RE: TCL for Paving Permit - New Mexico Beef Jerky (J14D185)

The purpose of this letter is to address comments received on December 5, 2023 regarding a paving permit for lots 14, 15, 16, and 17, Block 21, Albright Moore Addition, located on 5<sup>th</sup> Street between Kinley Avenue and Constitution Avenue. Attached for your review is a signed traffic scoping form and a revised site plan reflecting the requested changes and below are responses to the comments.

PROJECT NAME		PROJECT NO.	
		23052	
DESIGNED BY:		R/JF	
DRAWN BY:		R/JF	
CHECKED BY:		R/JF	
DATE:		DECEMBER 2023	
SHEET TITLE		TRAFFIC CIRCULATION LAYOUT	
SHEET NO:		C-2.0

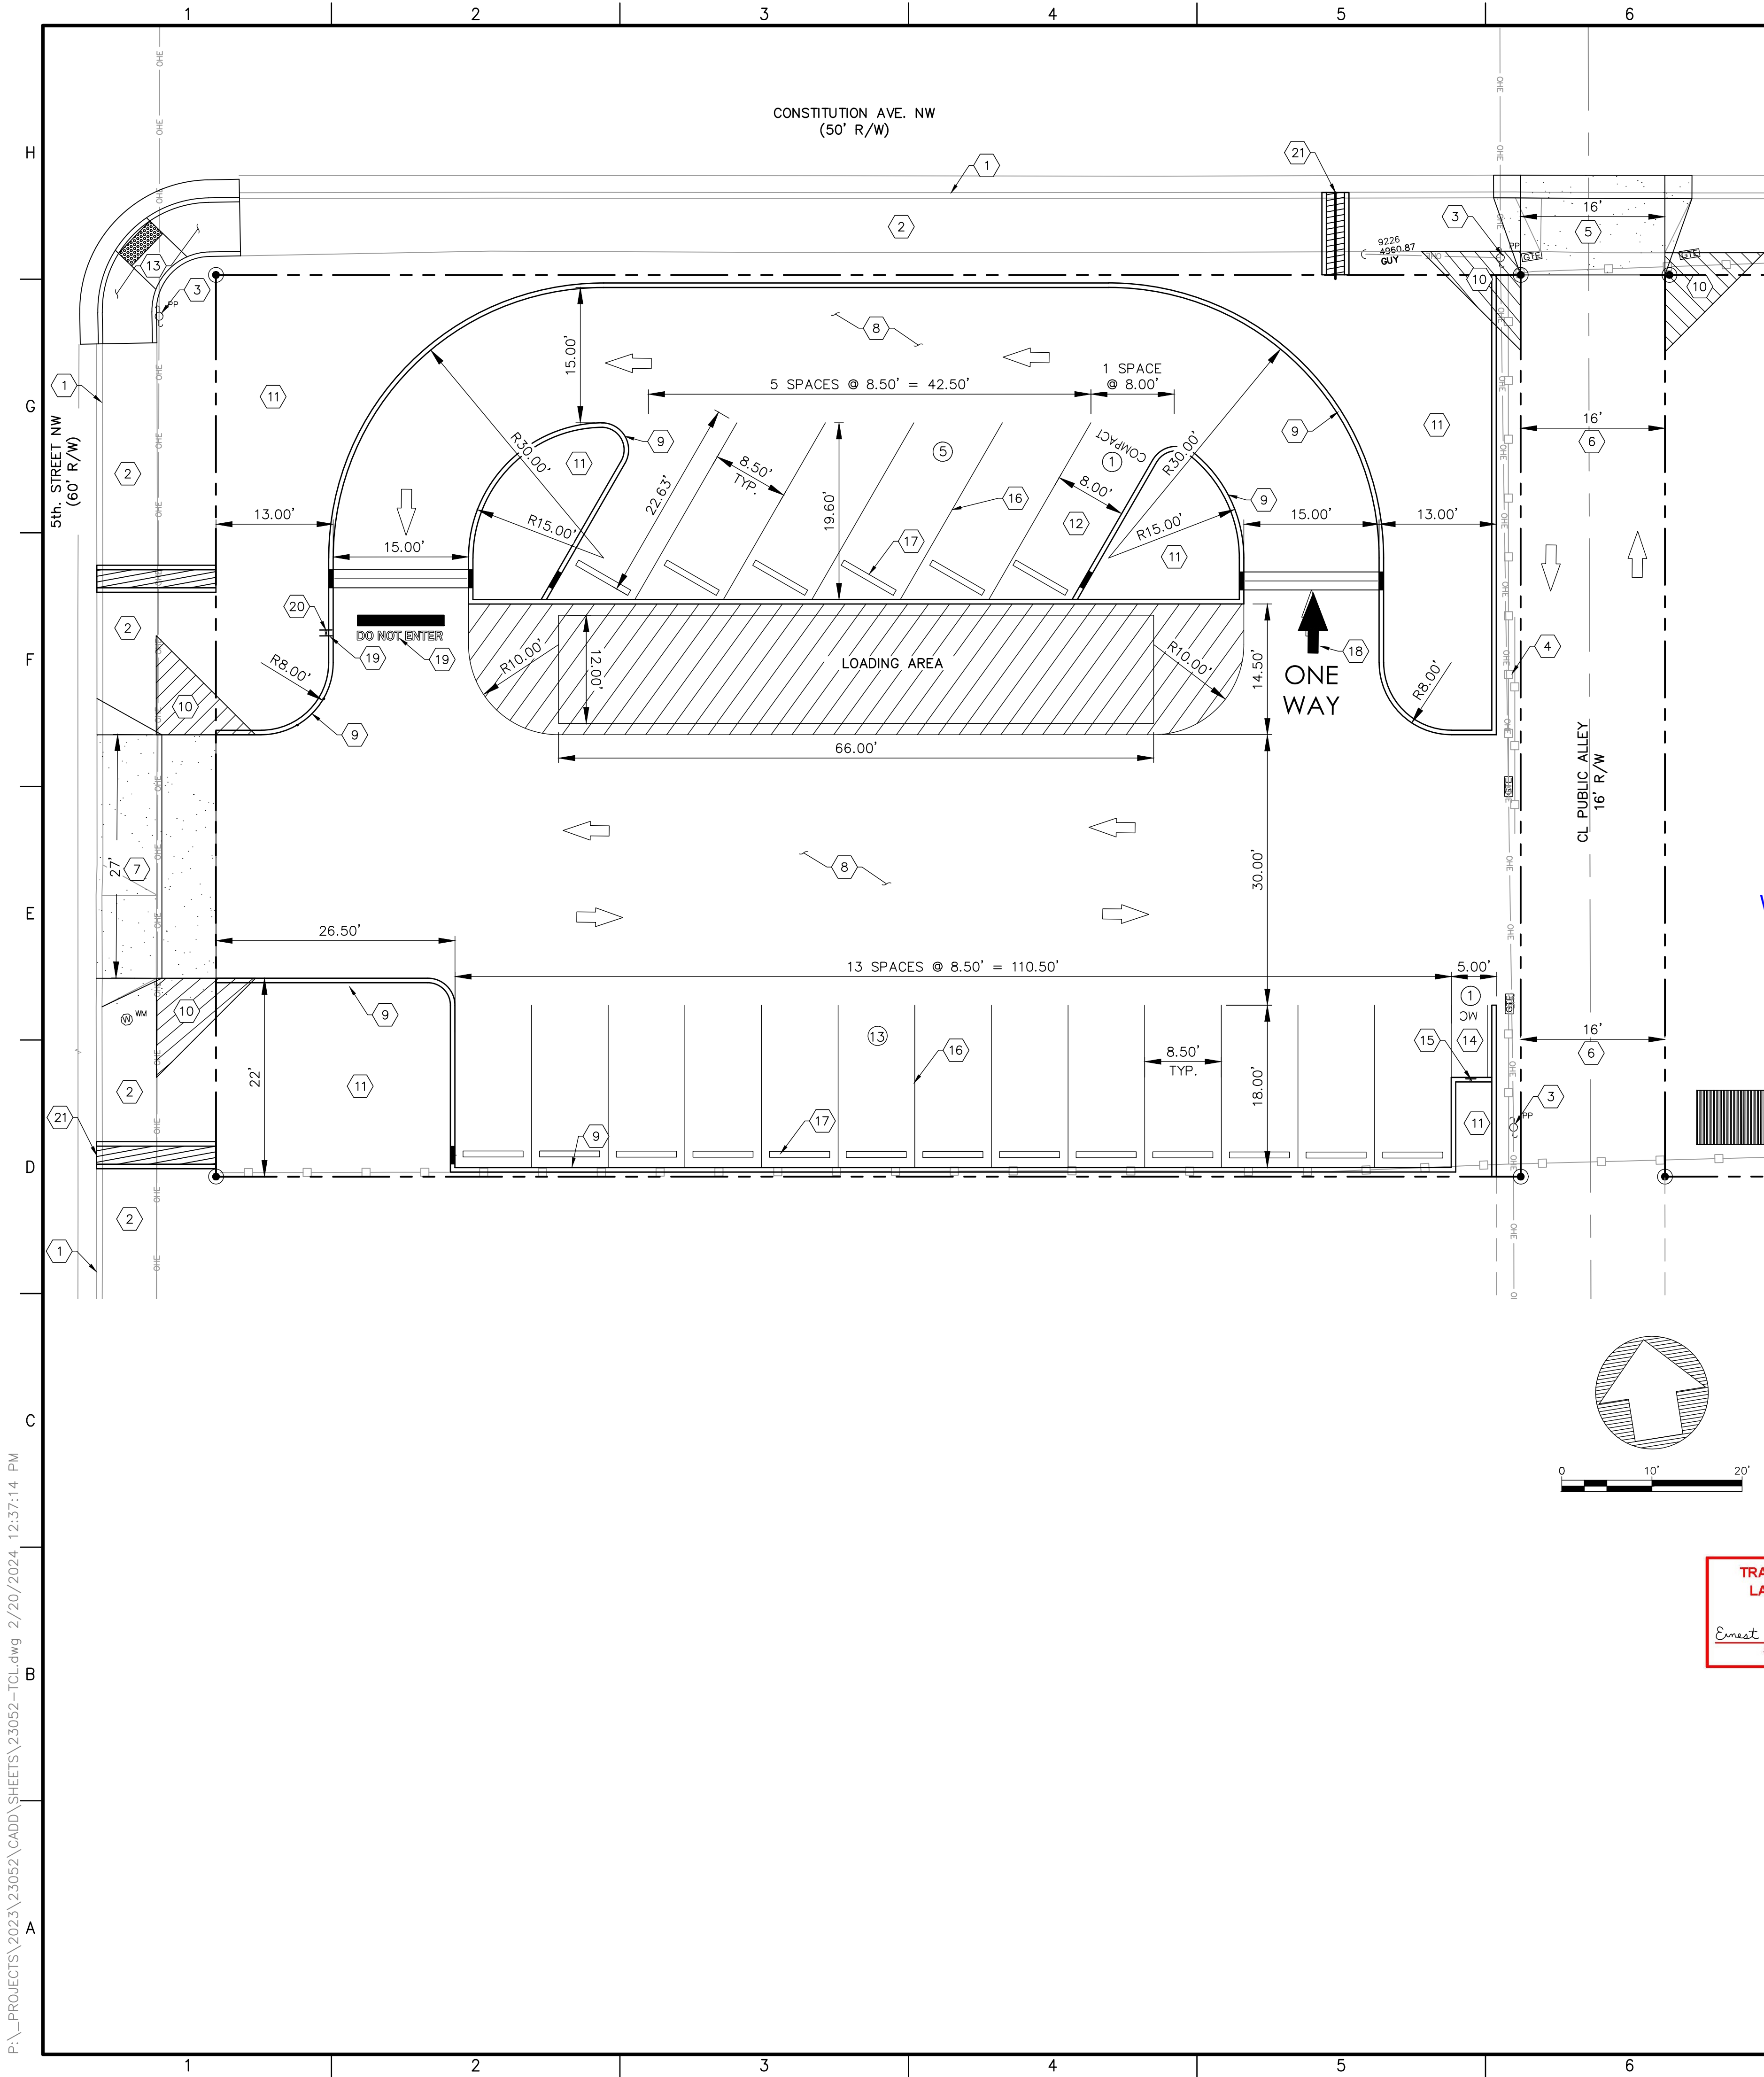
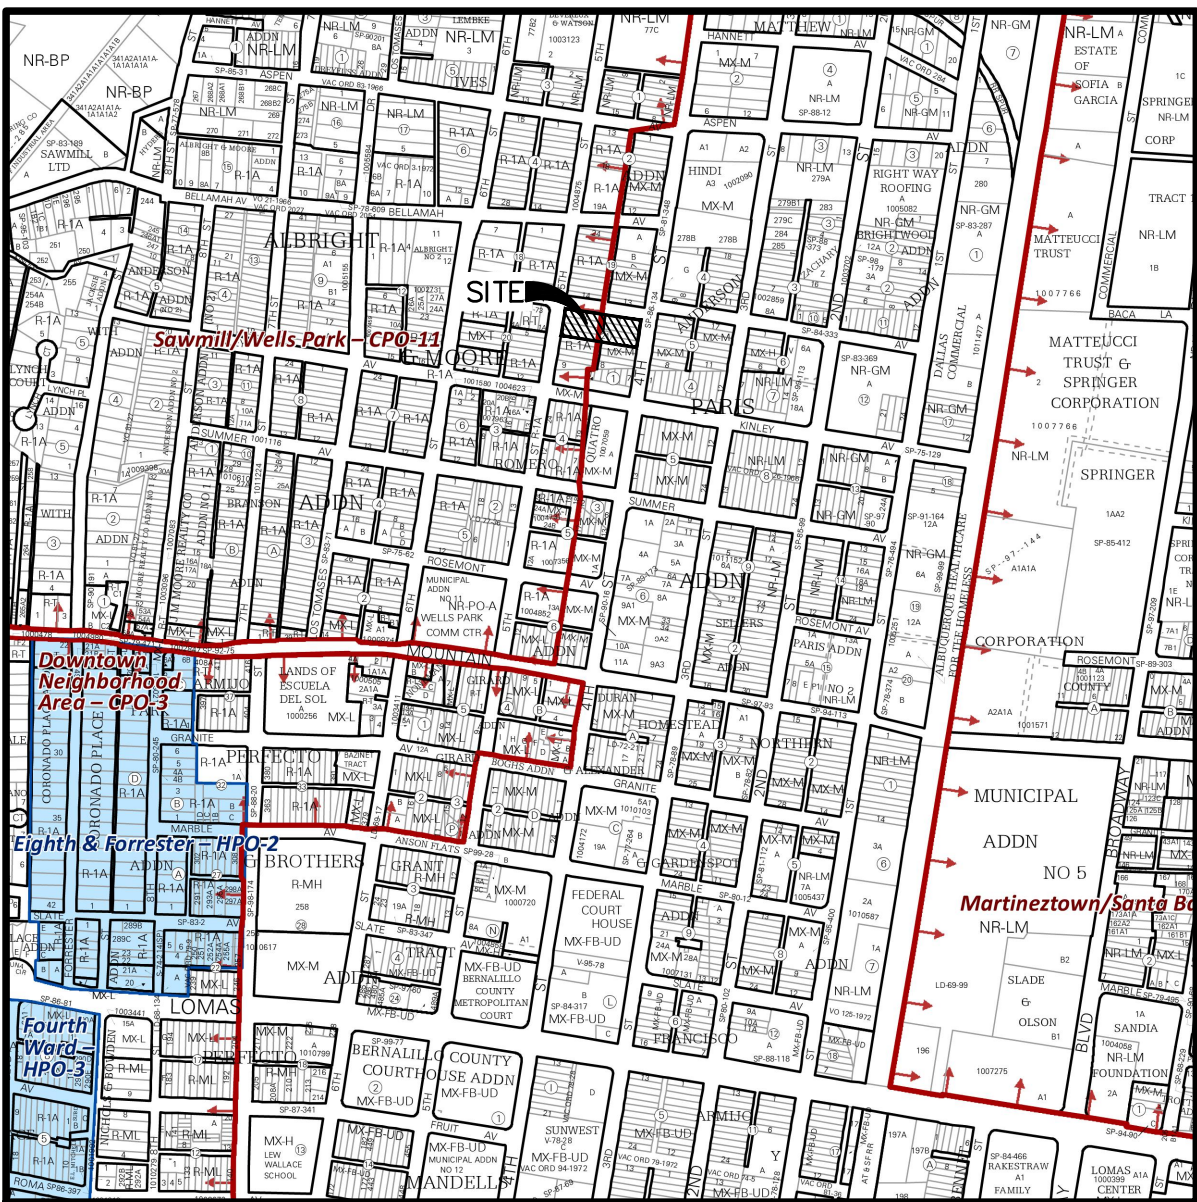
5. Show on the site plan the radius for the one way drive aisle.  
A 30' radius has been added to the one-way drive aisle, as shown on the attached TCL.

6. Minimum width for regular parking space is 8.5 ft. or Label the small parking spaces by placing the words "**COMPACT**" on the pavement of each space.  
The smaller space has been labeled, "COMPACT," as shown on the attached TCL.

7. Please revise the keynotes on the site plan. Key note 13 should be referred to paving the parking lot.  
Please see attached TCL for revision of Key Note.

9. ADA curb ramp at the corner of Constitution Ave and 5<sup>th</sup> St. must be updated to current standards and have truncated domes installed.  
Updated as requested. See attached TCL.

10. Provide "MC" parking sign.  
Updated as requested. See attached TCL.
11. Add a note stating "All broken or cracked sidewalk must be replaced with sidewalk and curb & gutter." A build note must be provided referring to the appropriate City Standard drawing.  
Updated as requested. See attached TCL.
